Planning consultation: Hybrid - mixed use development including 1,175 new dwellings, 60 close care dwellings, retail & employment space including a new medical centre, new school, creation of areas of open space etc

Location: Heyford Park, Camp Road, Upper Heyford, Bicester OX25 5HD

SUMMARY OF NATURAL ENGLAND'S ADVICE

NO OBJECTION

FIG 12 SITE BOUNDARY AND DESIGNATED SITES

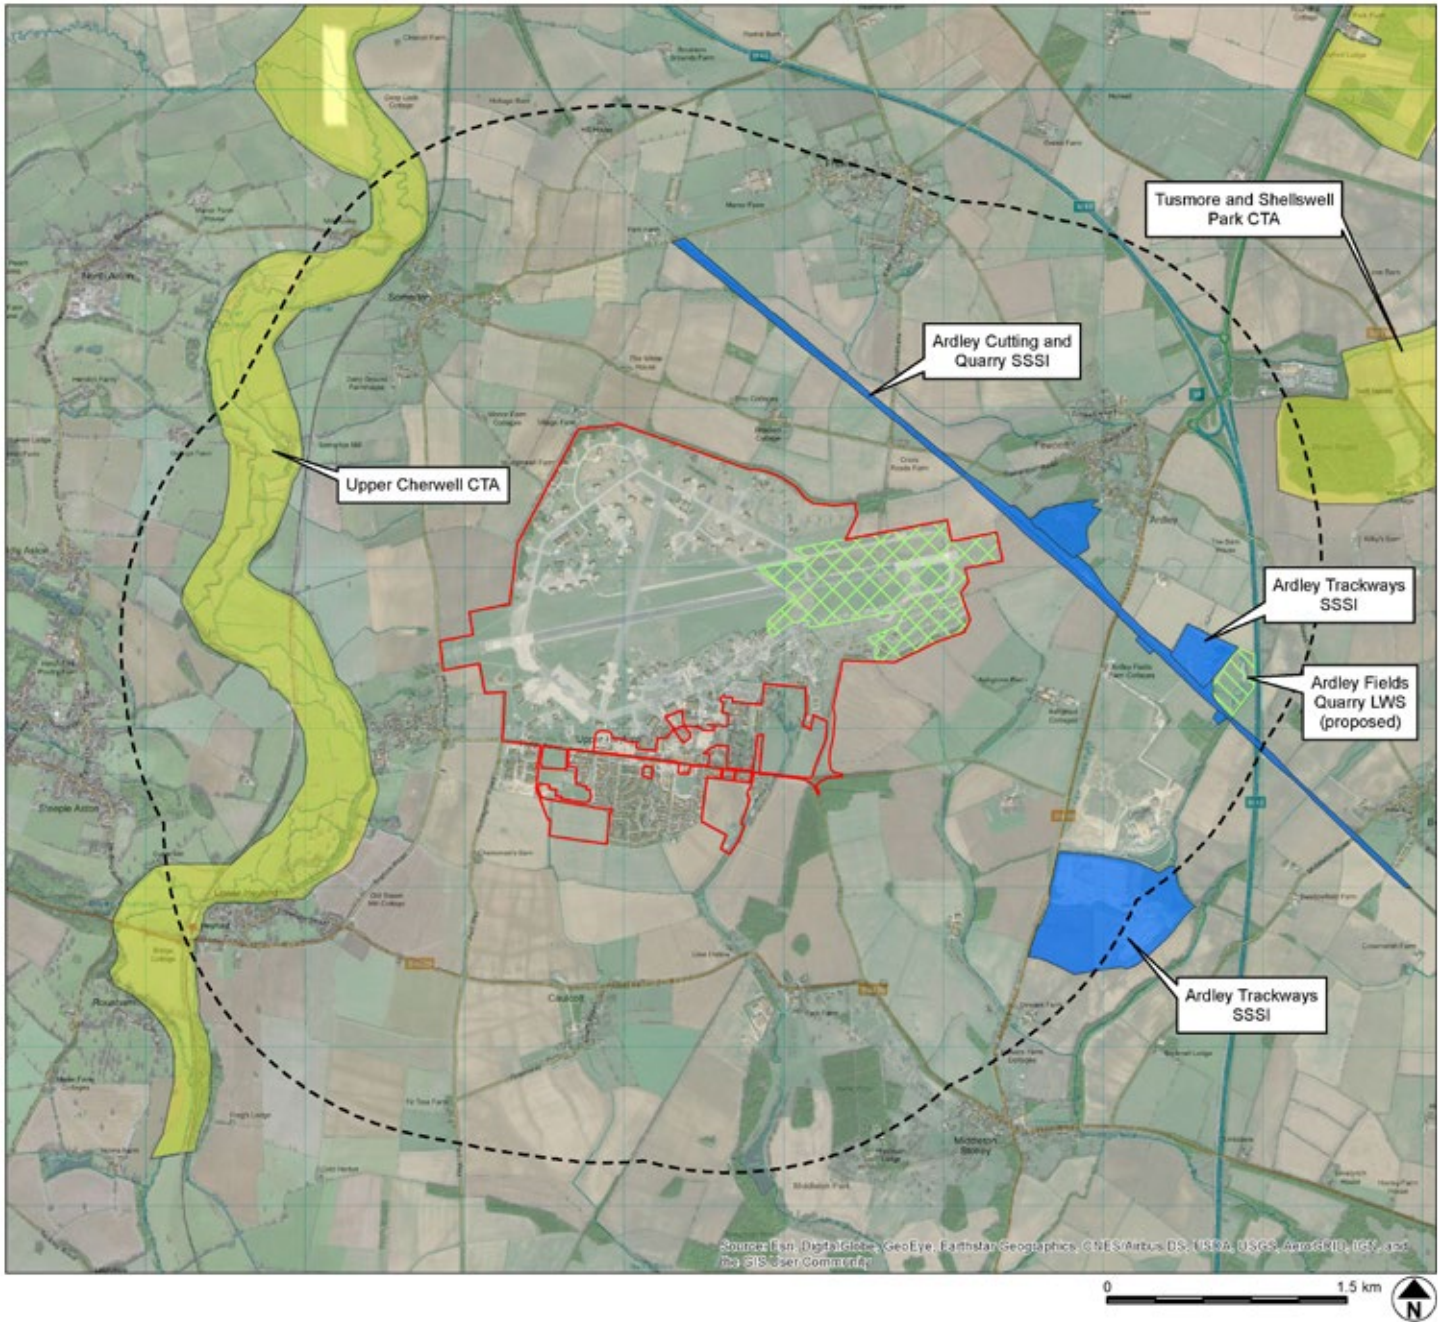
The Upper Heyford Airfield Local Wildlife Site contains, amongst other habitats, species rich lowland calcareous grassland (a priority habitat) 7.5ha of which would be lost as a result of this development. It is proposed that this loss is compensated for through habitat creation; compensation proposals should be subject to the highest scrutiny. Their viability is likely to be reliant on long-term monitoring and management, and when considering proposals involving compensation, it is important to recognise that some habitats are almost impossible to create in the short term – this should be reflected in the decision to support proposals involving compensation and the scale of the compensation proposed.

The creation of the compensatory habitat to the west of the airfield misses the opportunity to enhance habitat connectivity between Ardley Cutting and Quarry SSSI and the Upper Heyford Airfield Local Wildlife Site; we advise that, if compensatory habitat were to be provided on arable land to the east of the airfield, this would be likely to achieve greater gains for biodiversity through improved habitat connectivity.

Where habitats are created as mitigation or enhancement for a development, the proposals must include sufficient detail. This should be underpinned by robust science and evidence to ensure that the habitats and species they support meet, and are maintained at, the required quality. Natural England recommends that a management plan and monitoring programme should be produced for all habitats subject to creation or restoration as part of the mitigation for the impacts of this application and, should the local planning authority be minded to grant permission for this application, such a strategy is secured through an appropriately worded condition. In addition, funding should be secured for the implementation of the management plan in perpetuity. A Section 106 agreement may be the most appropriate means of securing this.
